Report of the Head of Planning, Transportation and Regeneration

Address 8 LINKSWAY NORTHWOOD

Development: Details pursuant to conditions 3 (Materials), 4 (Site Clearance) and 9 (SUDS) of planning permission Ref: 2645/APP/2019/853 dated 08/05/2019 (Variation of condition 2 (Approved Plans) of planning permission Ref: 2645/APP/2016/4571 (Two storey, 7-bed detached dwelling with habitable roof space, parking and amenity space involving demolition of existing dwelling)

LBH Ref Nos: 2645/APP/2019/1693

CONDITION 4
PROPOSED:
SITE SET UP PLAN

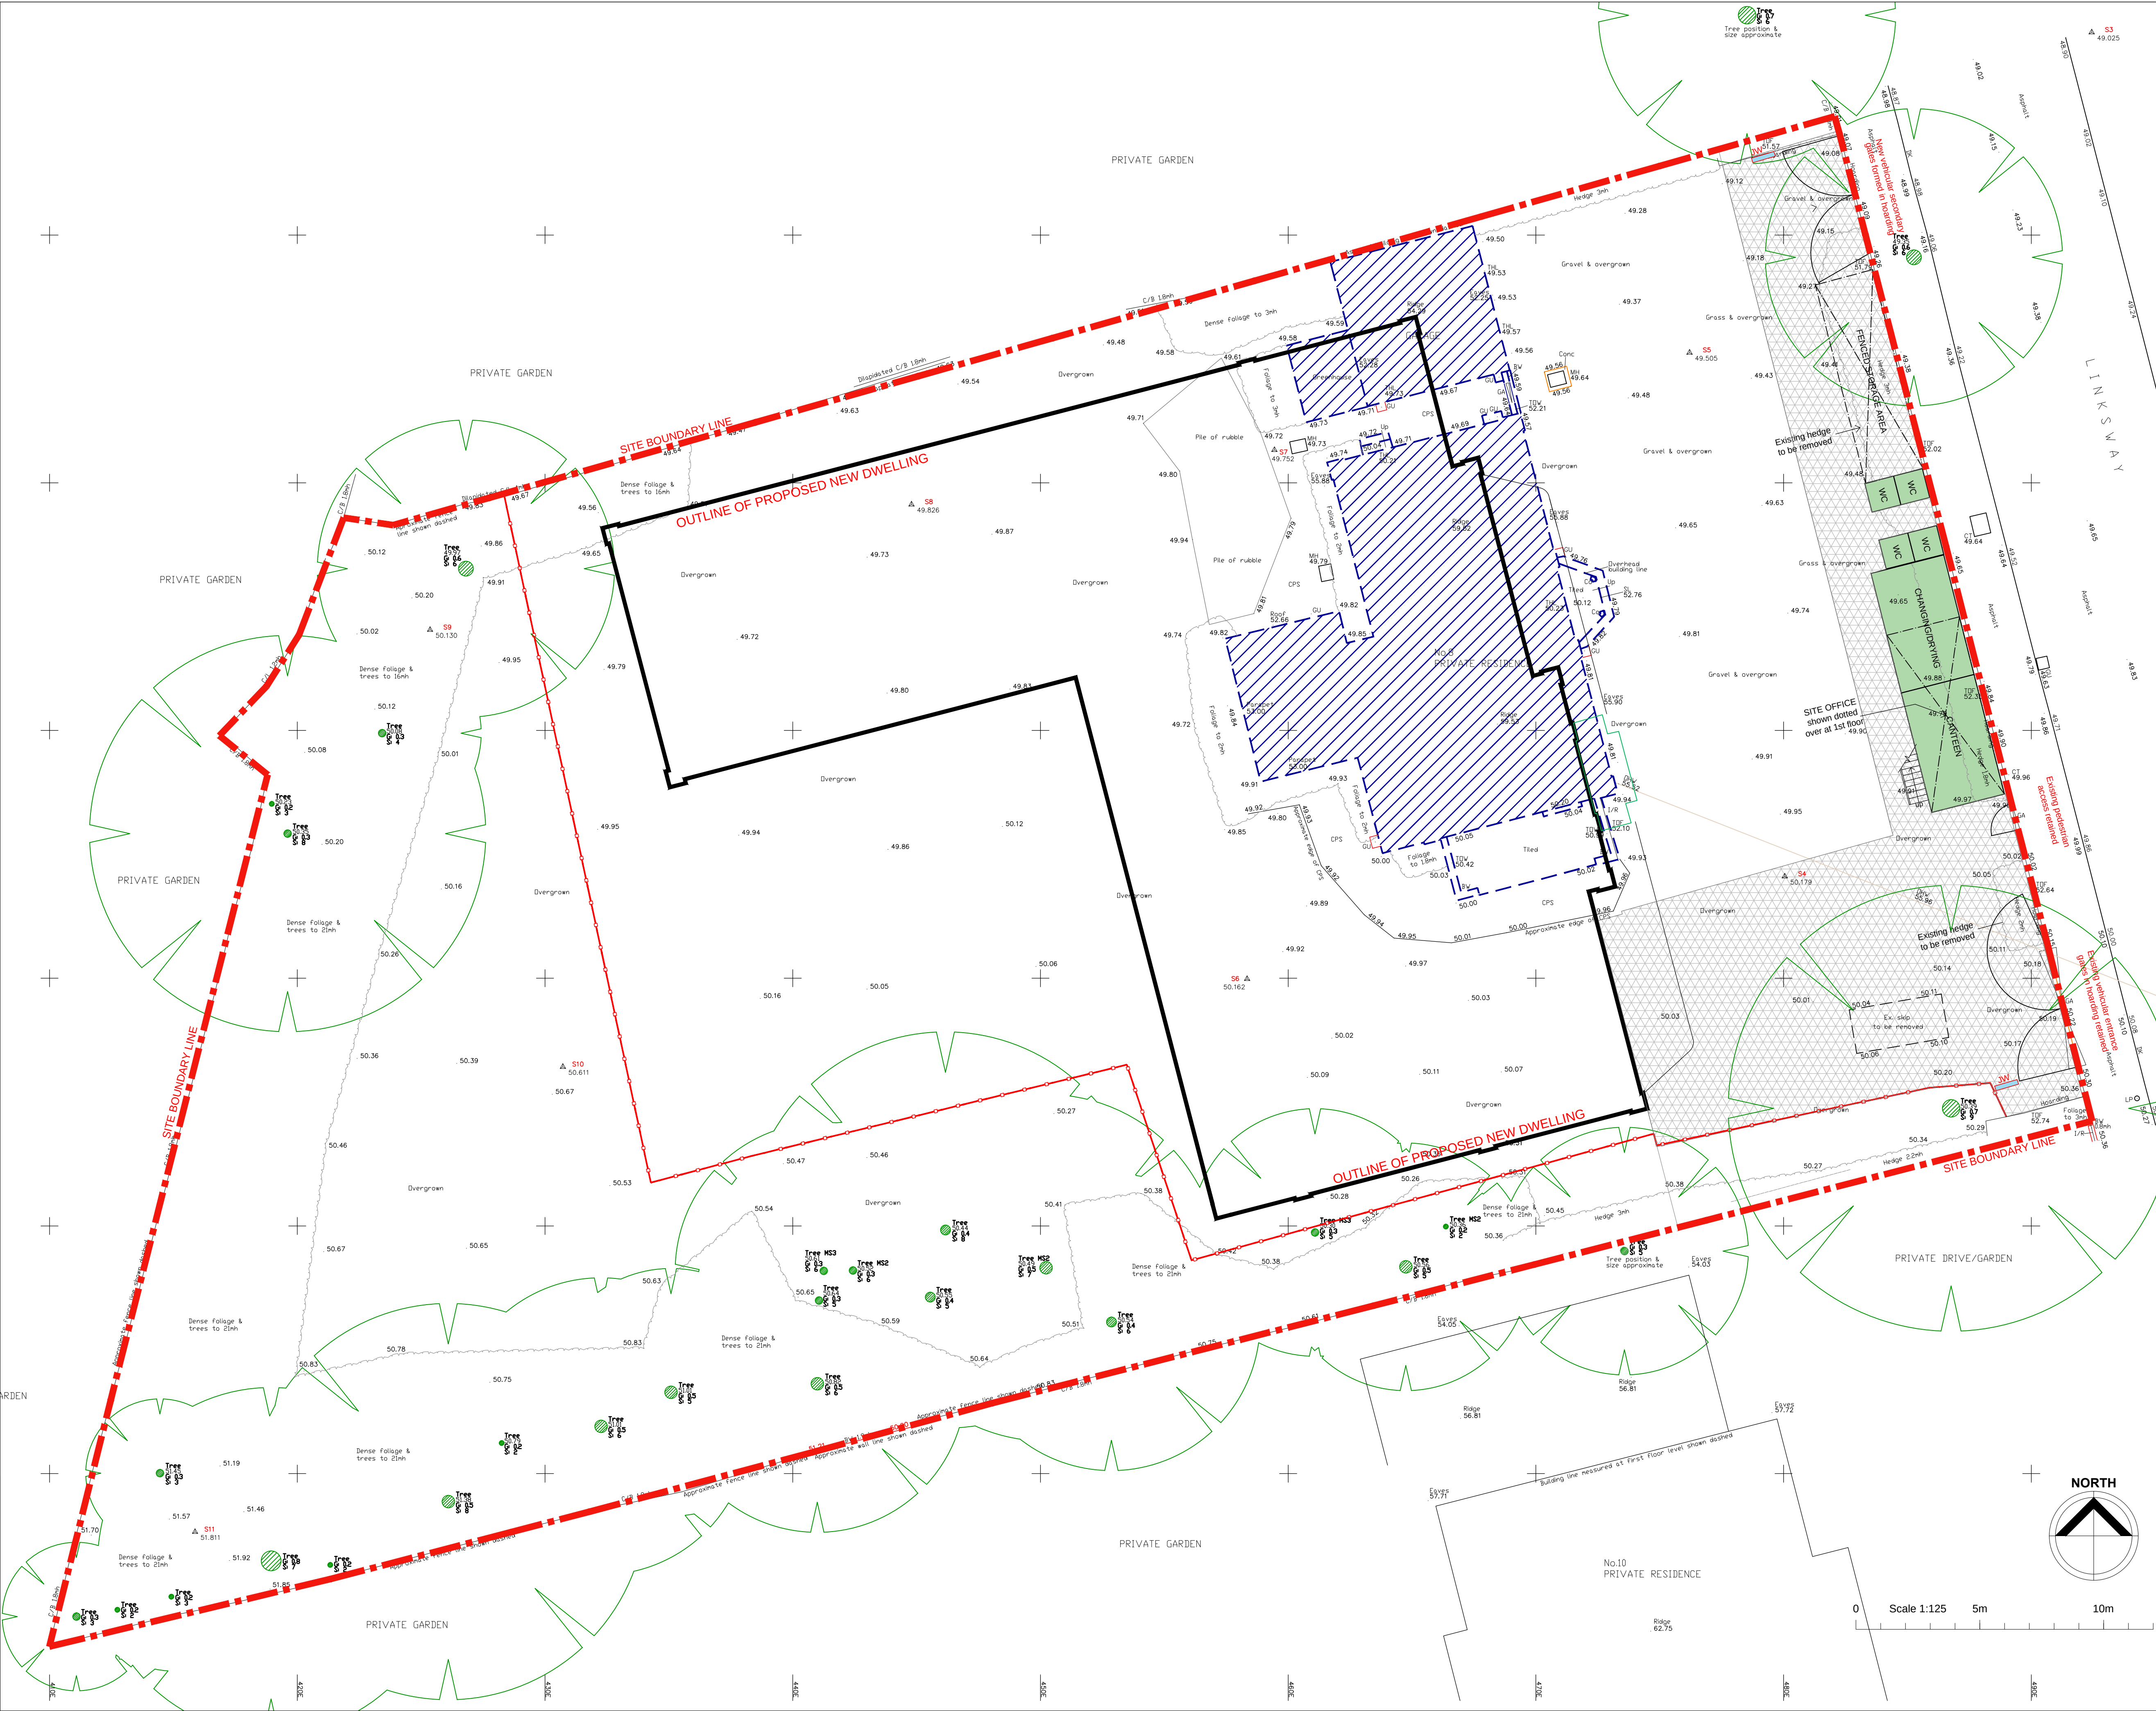
A tree report by Tree Sense has been submitted. The report incorporates a tree survey and assessment, provides a Tree Constraints Plan, Construction Exclusion Zone, Tree Protection Plan and an Arb Method Statement. The site set up plan by Seabrook shows the location of protective fencing and an area of 'no dig' geotextile panels. RECOMMENDATION No objection.
